**KIRKLEES METROPOLITAN COUNCIL  
INVESTMENT & REGENERATION SERVICE**

**Reference No:** 2020/62/92284/W

**Site Address:** 33, Wilshaw Road, Meltham, Holmfirth, HD9 4DZ

**Description:** Erection of single storey out building to provide home office/studio (within a Conservation Area)

PROPOSED PLAN OF STUDIO/OFFICE 1:50 @ A2

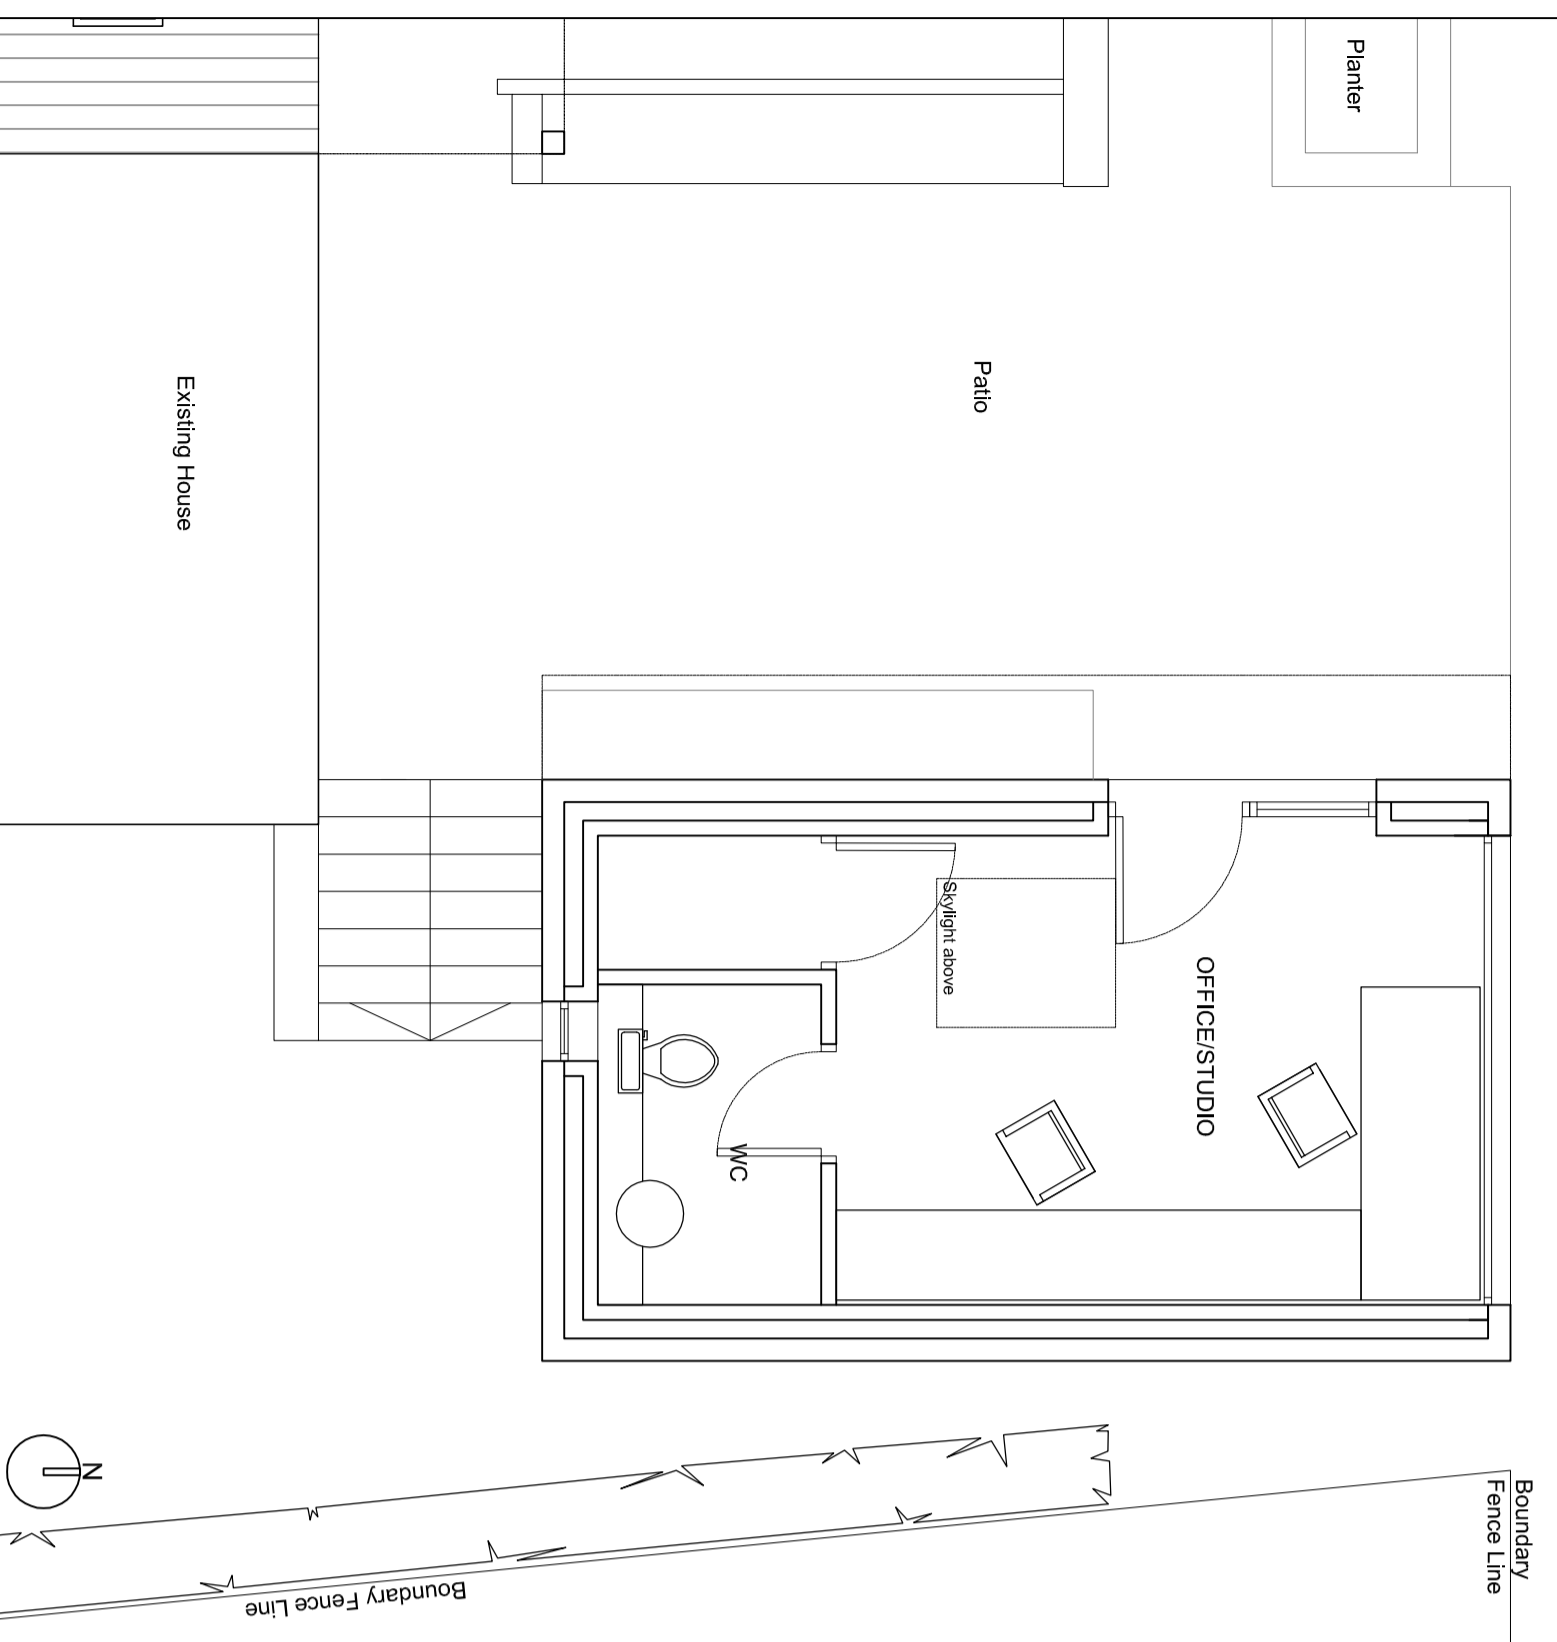
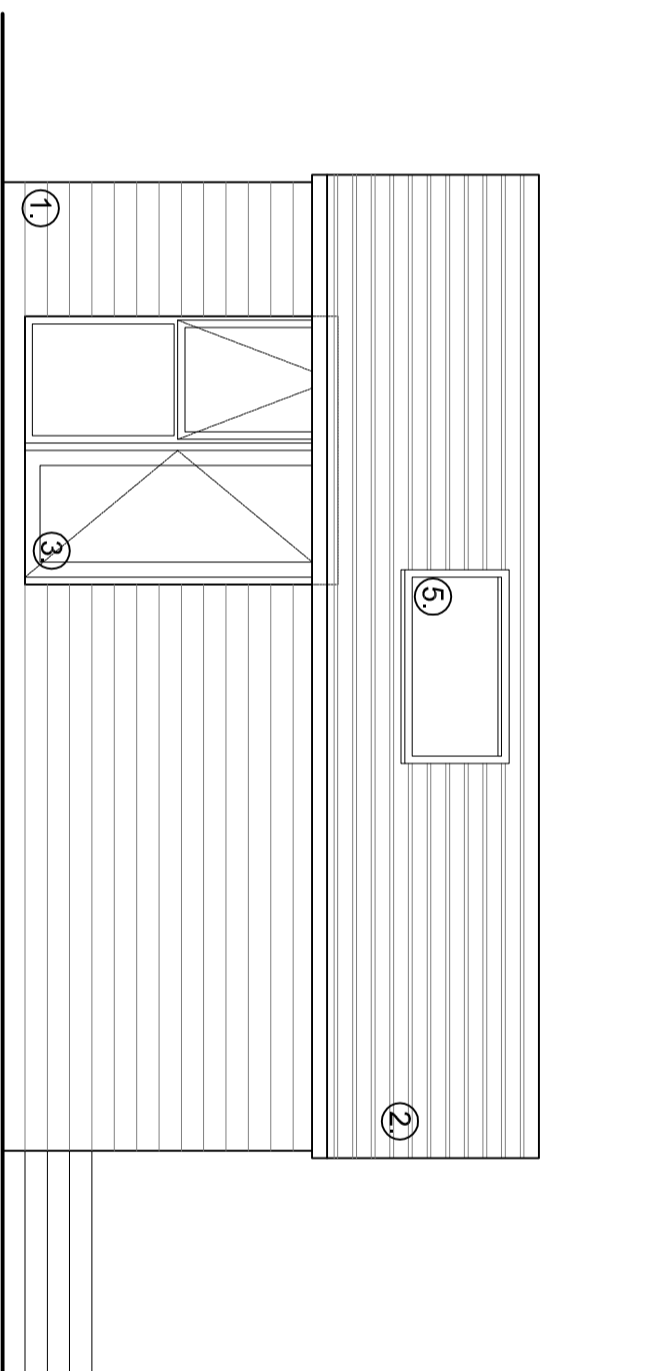
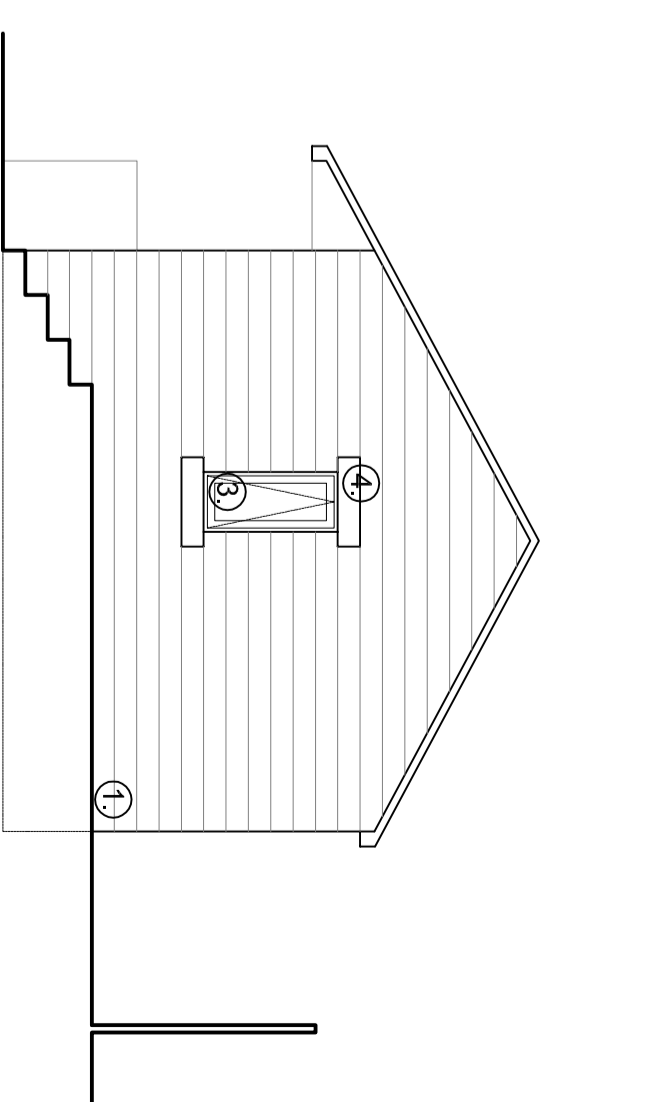
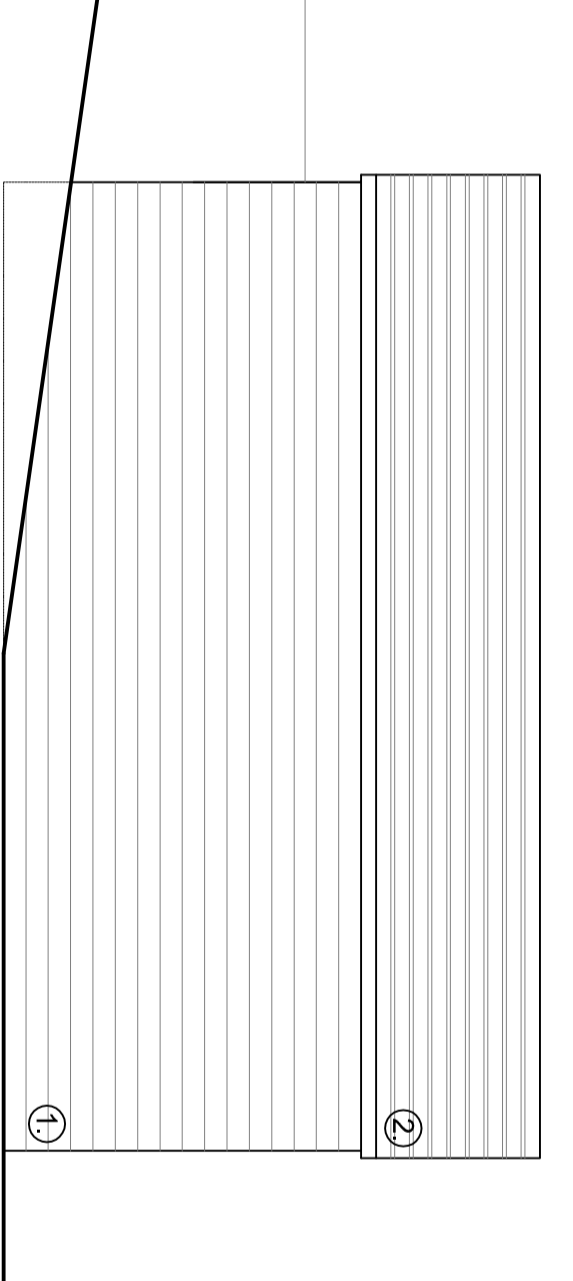
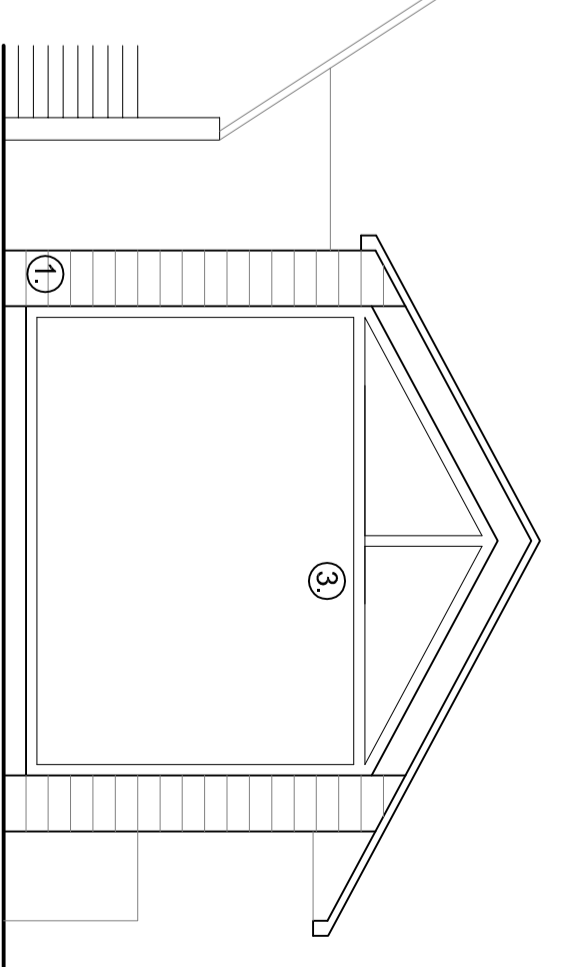
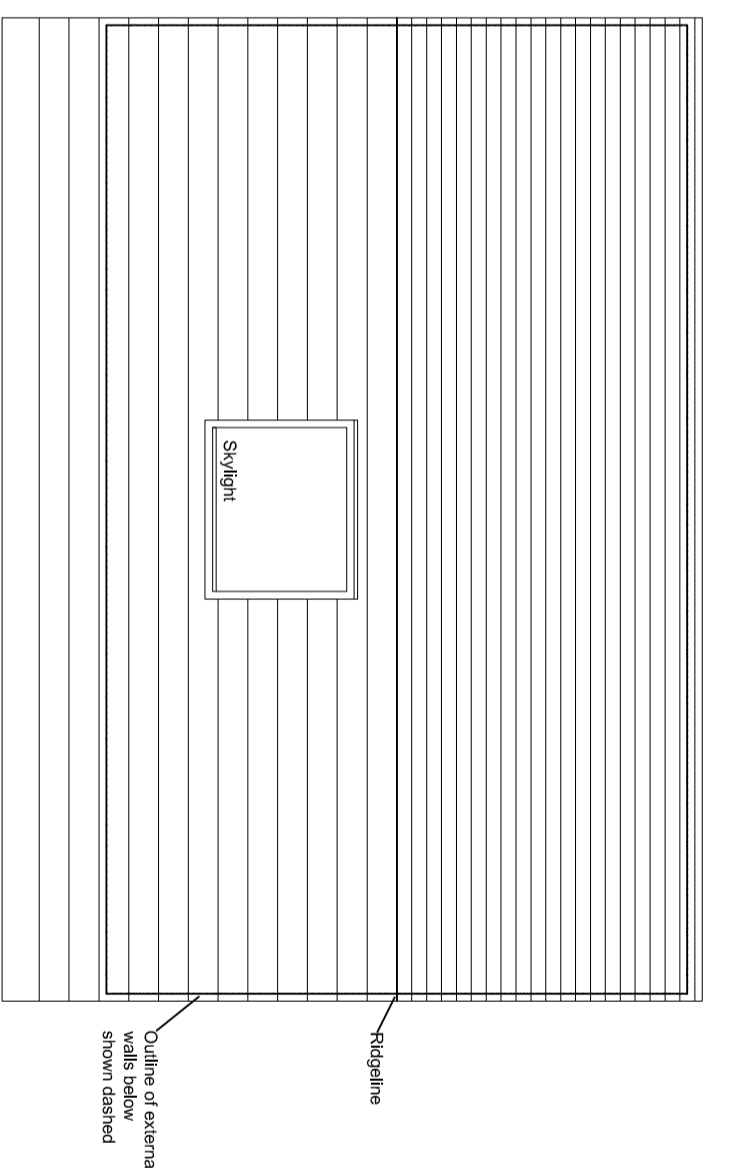
- The development should be constructed from matching natural stone, not the stated artificial.
- The proposal fails to preserve or enhance the conservation area and the adjacent Grade II listed church and would be contrary to Policy LP35 of the Local Plan and Policies in the NPPF.

- Is the proposed large opening on the northern elevation appropriate for a site within the conservation area?
- Sitting the building further to the north of the site would damage the amenity of adjacent properties by the increased level of built form to the property. If required the building should be re-sited away from neighbouring properties.

- The development should be constructed from matching natural stone, not the stated artificial.
- The proposal fails to preserve or enhance the conservation area and the adjacent Grade II listed church and would be contrary to Policy LP35 of the Local Plan and Policies in the NPPF.
- Is the proposed large opening on the northern elevation appropriate for a site within the conservation area?

**Response:** As set out above the design of the proposal is considered to be acceptable subject to a condition securing the use of natural stone. The impact on the conservation area is also considered to be acceptable. The adjacent listed building is approximately 55 metres from the proposed outbuilding and given that the building would be set down from the church it is not considered that the proposal would detrimentally affect the setting of the listed church.

3. Notwithstanding the details set out on the approved plans, the external walls of the hereby approved outbuilding shall be constructed from natural stone which shall in all respects match those used in the construction of the existing building.

4. The roofing materials of the hereby approved outbuilding shall be natural slate which shall in all respects match those used in the construction of the existing building.
